**KIRKLEES METROPOLITAN COUNCIL
INVESTMENT & REGENERATION SERVICE**

DELEGATED DECISION TO DETERMINE PLANNING APPLICATIONS

Reference No:	2023/62/90464/E
Site Address:	126, Gomersal Lane, Gomersal, Cleckheaton, BD19 4JQ
Description:	Erection of extensions to form two-storey dwelling
Recommending Officer:	Jennifer Booth

DECISION - REFUSED

Proposed Floor Plans & Elevations
Date: JAN23
Designed: RF
Scale: As indicated
Drawn: RF
Drawing No: 23-004-02
Checked: JW
Revision: -

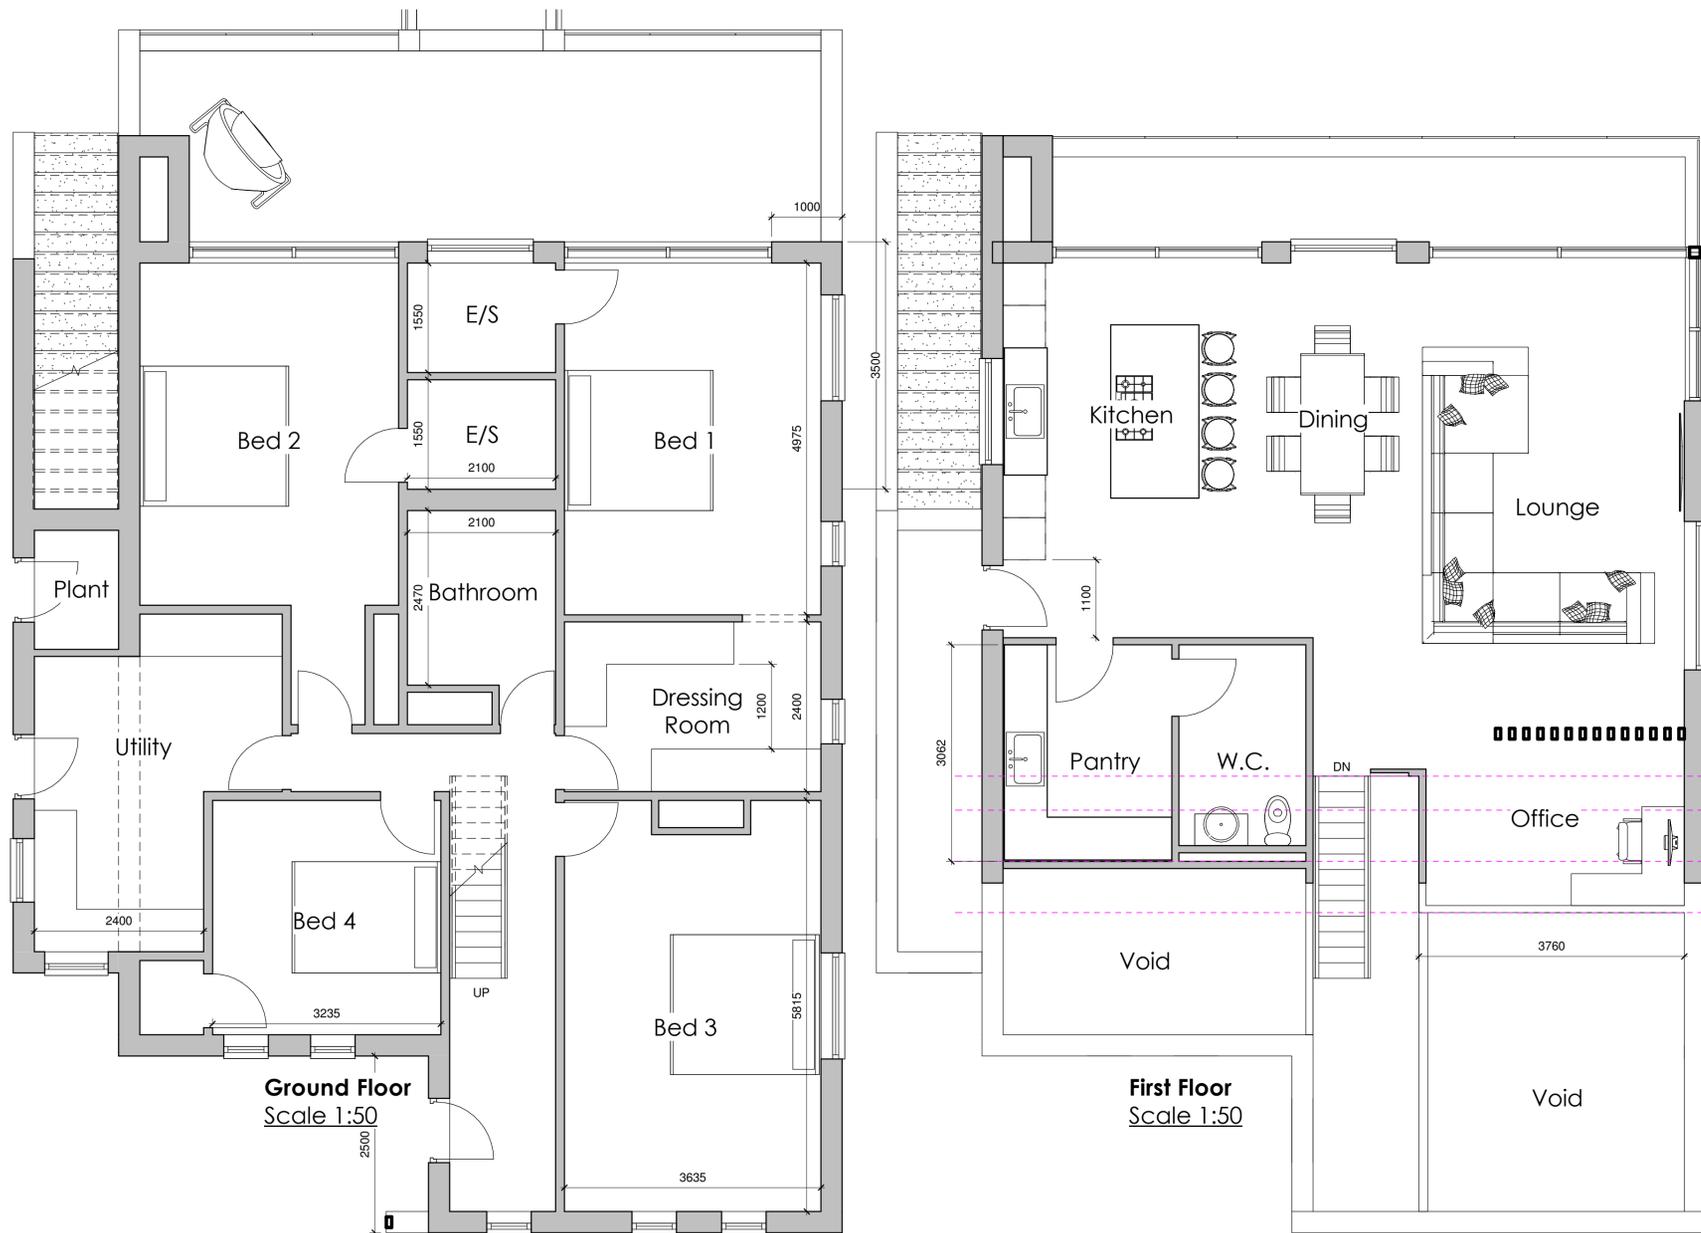
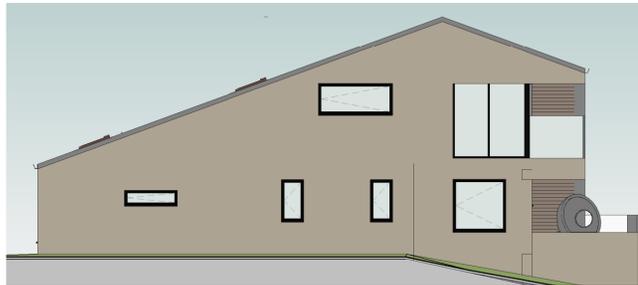
The works proposed include a single storey element to the front projecting 2.7m across part of the width of the dwelling (6.4m). The depth of the dwelling would be increased from 11.7m (including the sunroom) to 15.5m. The overall height of the dwelling would be increased from 5.8m to 7m with a single storey appearance from the front and two storey at the rear. The walls would be clad with stone.

The plans show the formation of a terrace on the ground level at the rear along with a recessed balcony at first floor with full enclosure on the boundary with the neighbouring dwelling.

The existing property is a modest, brick built bungalow with dormers, set in substantial grounds. The proposals would see a significant increase in the massing, extending forwards slightly and taking the height of the property upwards. Together with wholesale alterations to the fabric of the building replacing the brick exterior with stone and incorporating very modern fenestration with glazing features. It is noted that from the front of the property, the appearance is as a bungalow with a two storey appearance to the rear. Overall, the significant alteration to the property would not be subservient and the original house would no longer be recognisable.

Paragraph 4.4 of the House Extensions & Alterations SPD does allow for some contemporary design. However, it would have to be demonstrably appropriate for the site context and make a positive contribution to the wider area. In this instance, given the prominence of the site together with the surrounding development, the works would be inappropriate and incongruous, particularly with respect to the significant shift in the character of the dwelling. As such, whilst this property could potentially be extended, the design would have to be altered, the scale reduced and the materials amended. The current scheme is considered to be unacceptable in terms of visual amenity.

The Little Gomersal Conservation Area is described as a small, closely knit textile settlement from the late 18th century which is characterised by narrow lanes and walls giving a strong sense of enclosure. The host property is set back from the boundary with the Conservation Area although there are strong connecting views when travelling along Gomersal Lane from the west. The proposed side elevation would have a significant bulk and massing which would neither preserve nor enhance the character of the conservation area. Policy LP35 of the Local Plan and Chapter 16 of the NPPF state that harm to heritage assets should not be allowed without a proportionate justification. The scheme would have a less than substantial harm in terms of impact on the heritage asset with no demonstrable public benefit and, as such, would not be considered to be acceptable in terms of the impact on the conservation area.

1. The proposed extensions and alterations, by reason of the design, scale, bulk and massing in addition to the change of materials for the dwelling, would not appear sympathetic or subservient to the host property, resulting in an incongruous form of development detrimental to the wider street scene and harmful to the Little Gomersal Conservation Area. The harm is considered to be less than substantial for which no public benefit has been demonstrated to outweigh the harm caused, contrary to the aims of paragraphs 199-202 of the National Planning Policy Framework (NPPF). It is therefore considered that the development proposed would not accord with the aims of Chapter 16 of the NPPF, Policies LP24 and LP35 of the Kirklees Local Plan or Key Design Principles 1-2 of the House Extensions and Alterations SPD.
